Date: 4 November 2014
Your reference: SSD 5300
Our reference: DOC14/259540
Contact: Calvin Houlison
4224 4179

RE: Kembla Grange Resource Recovery Centre EIS Exhibition (SSD 5300)

OSD BASIN B DETAILS

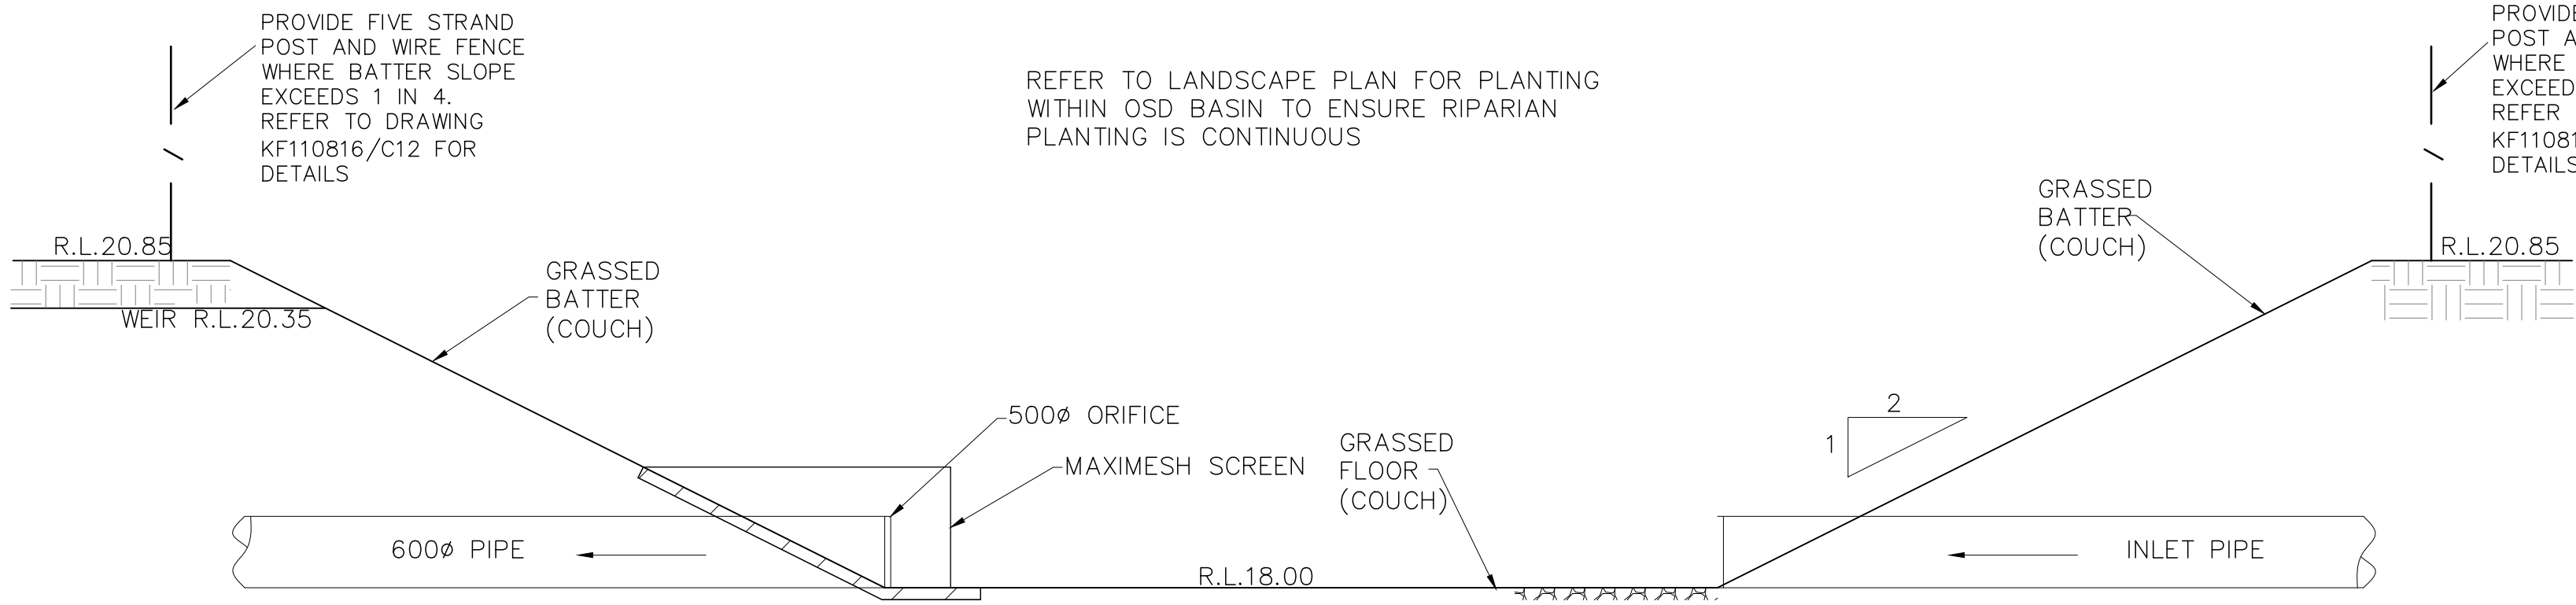
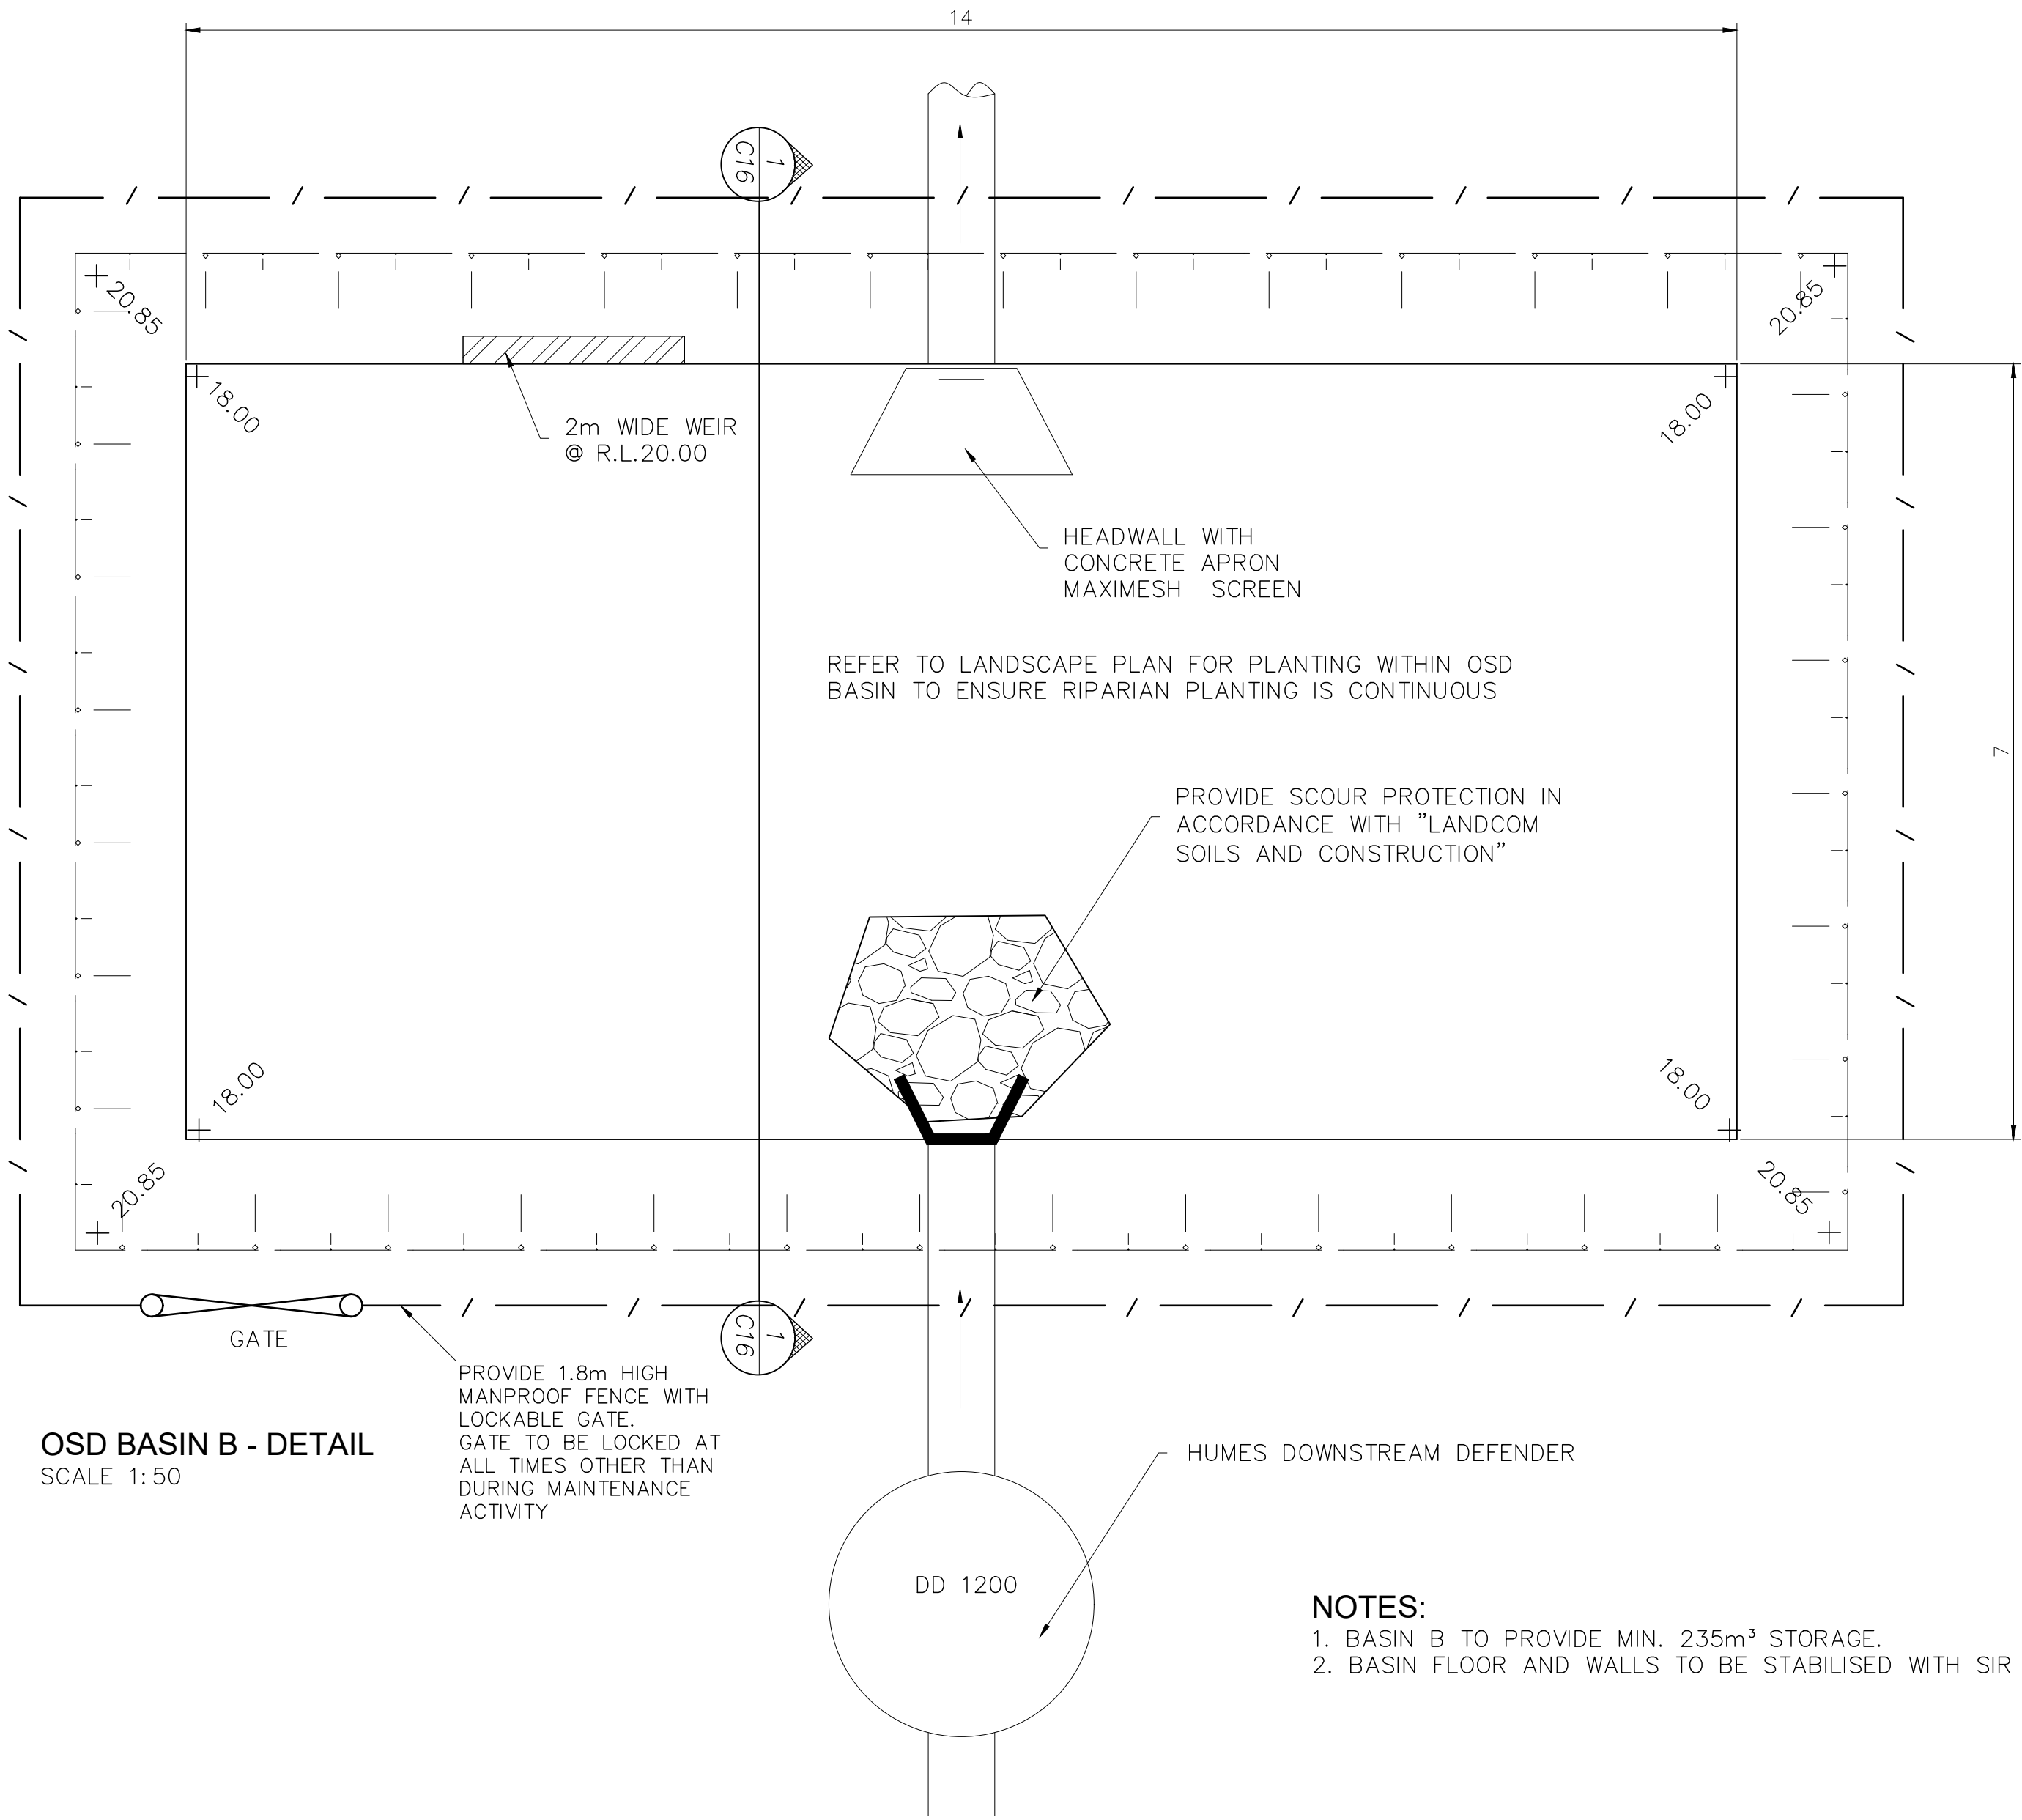
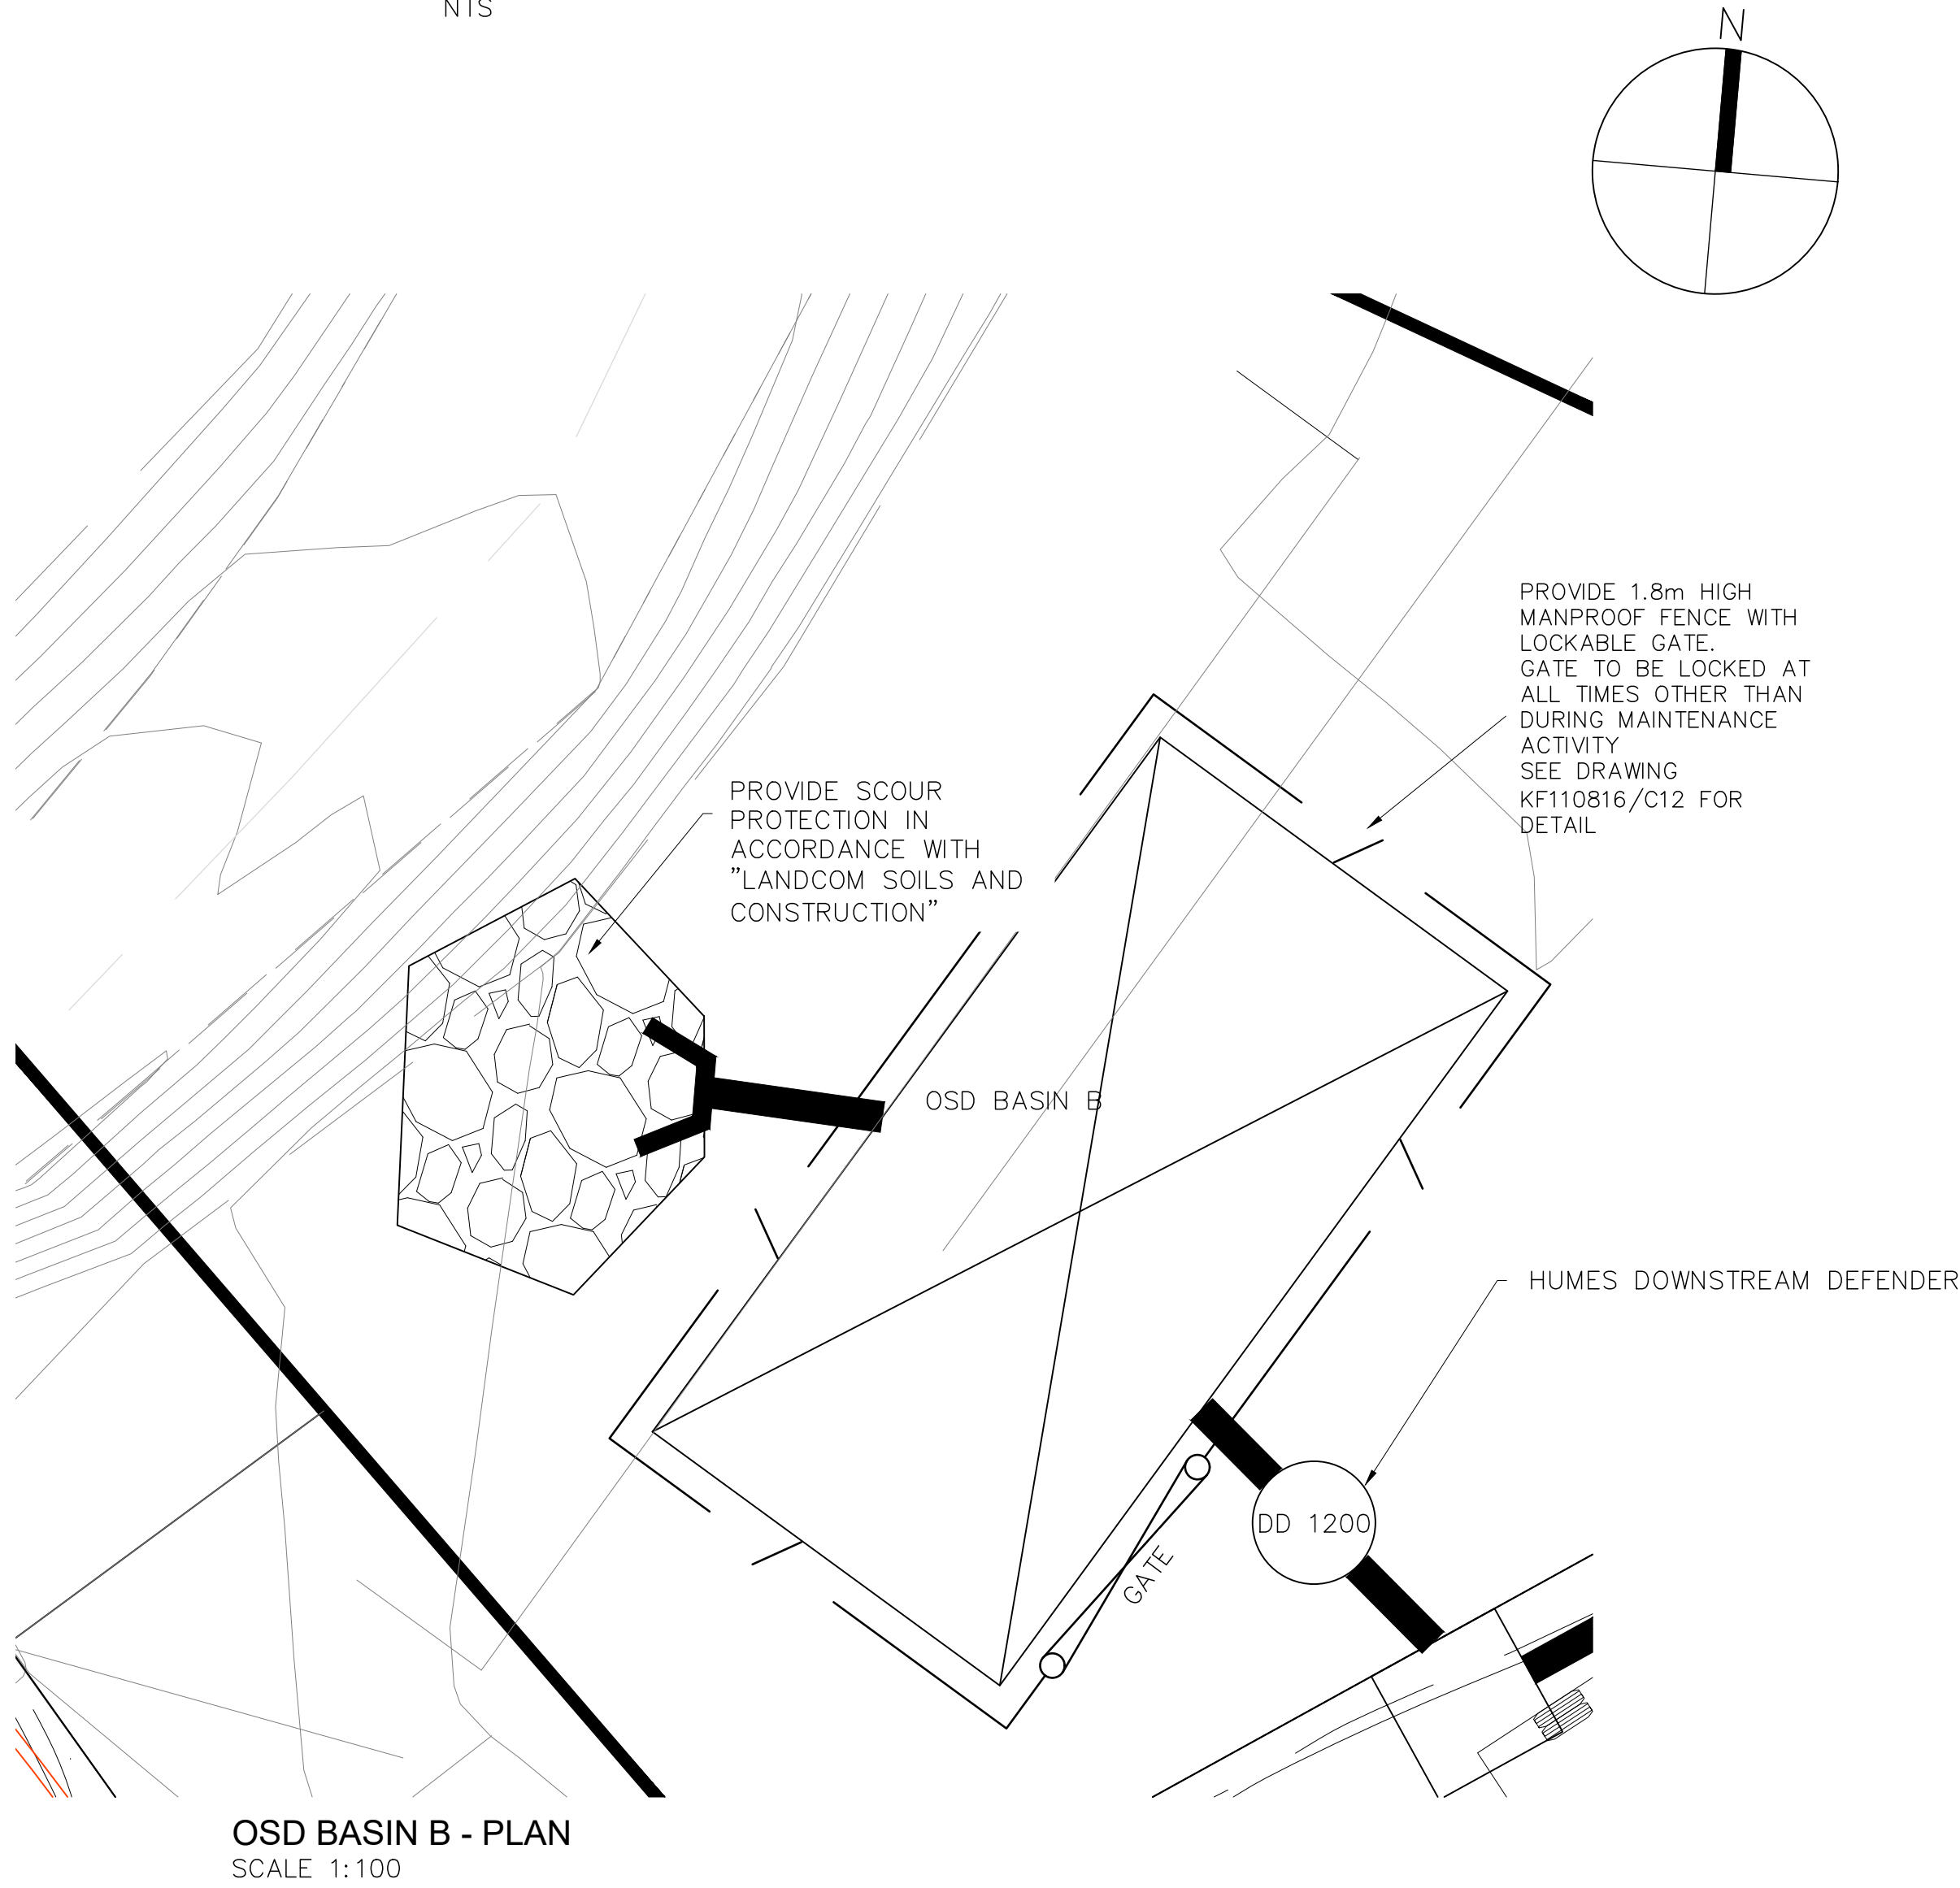
- DPE should be satisfied that the floodplain management and water quality matters raised previously have been addressed. This includes contingencies related to the performance of stormwater infrastructure to minimise impacts on Lake Illawarra sensitive receiving waters should design rainfall be exceeded. These include the shredding runoff pond, water recycling pond and detention basins A and B.

From the information available to OEH, consideration should be given to these issues in their entirety, particularly with regard to the management of potential downstream adverse flood impacts and flood isolation hazards. It is unclear whether adequate consideration has been given to contingencies related to the performance of stormwater infrastructure should design rainfall be exceeded. It is recommended that a risk management approach be developed in line with current engineering best practice to minimise impacts on the environmentally sensitive receiving waters of Lake Illawarra.
